Rezoning Transportation Analysis
Petition Number: Insert Zoning Petition #2020-194
General Location Identifier: Tax ID 11906424

Revision Log:

Date	Description
01-21-2021	First Review (KP)
02-12-2021	Second Review (KP)
03-25-2021	Third Review (KP)

**REZONING PLAN
RZ.01**

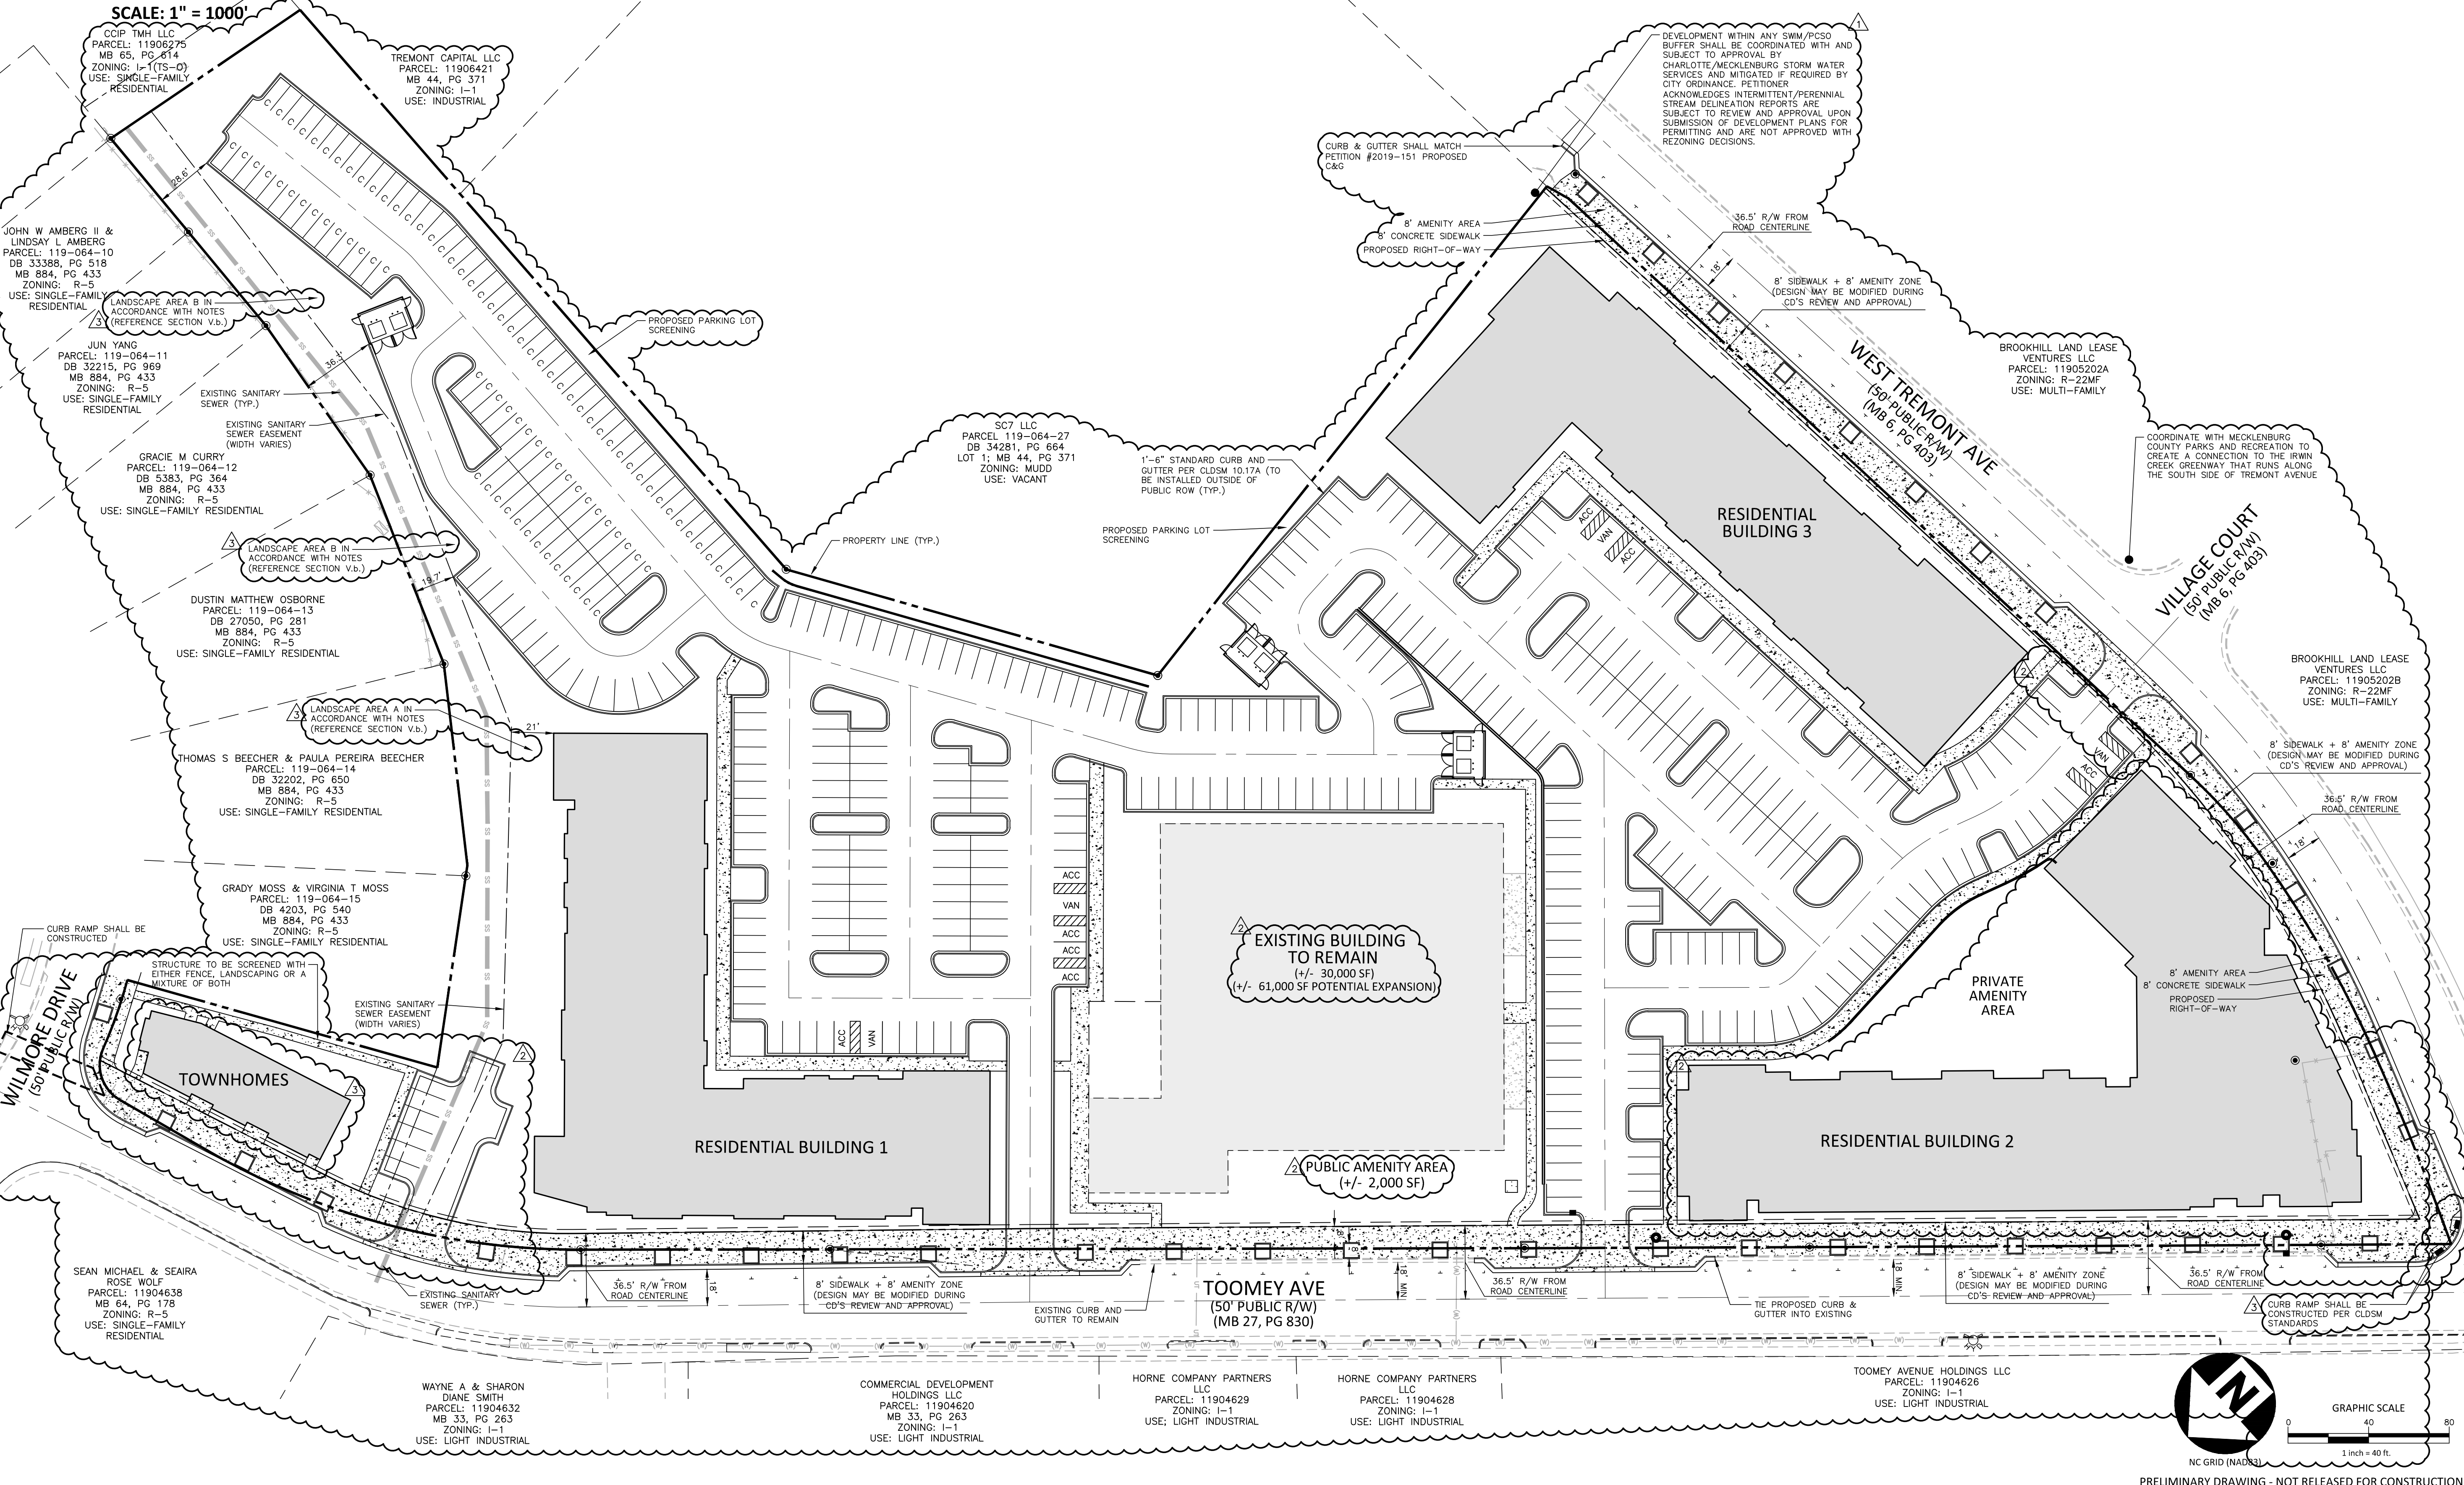
Update to Comment as a Result of the 03/18/2021: Please extend the amenity zone and sidewalk across the Wilmore Street frontage of PID 11906424.

10. Revise site plan and conditional note(s) to commit to construct a CLDSM 10.31A curb ramp at the southeast corner of the Toomey Avenue and Wilmore Drive intersection.

11. A site plan note(s) specifying dedication and fee simple conveyance of all rights-of-way to the City before the site's first building certificate of occupancy is issued is needed. CDOT requests rights-of-way set at 2' behind back of sidewalk where feasible

12. A site plan note specifying that all transportation improvements will be approved and constructed before the site's first building certificate of occupancy is issued is needed. The petitioner may phase

13. **New Comment as a Result of the 03/16/2021 Site Plan:** Revise the site plan and conditional notes to commit to construct two ADA curb ramps, in accordance with CLDSM, at the corner of Tremont Avenue and Toomey Avenue.
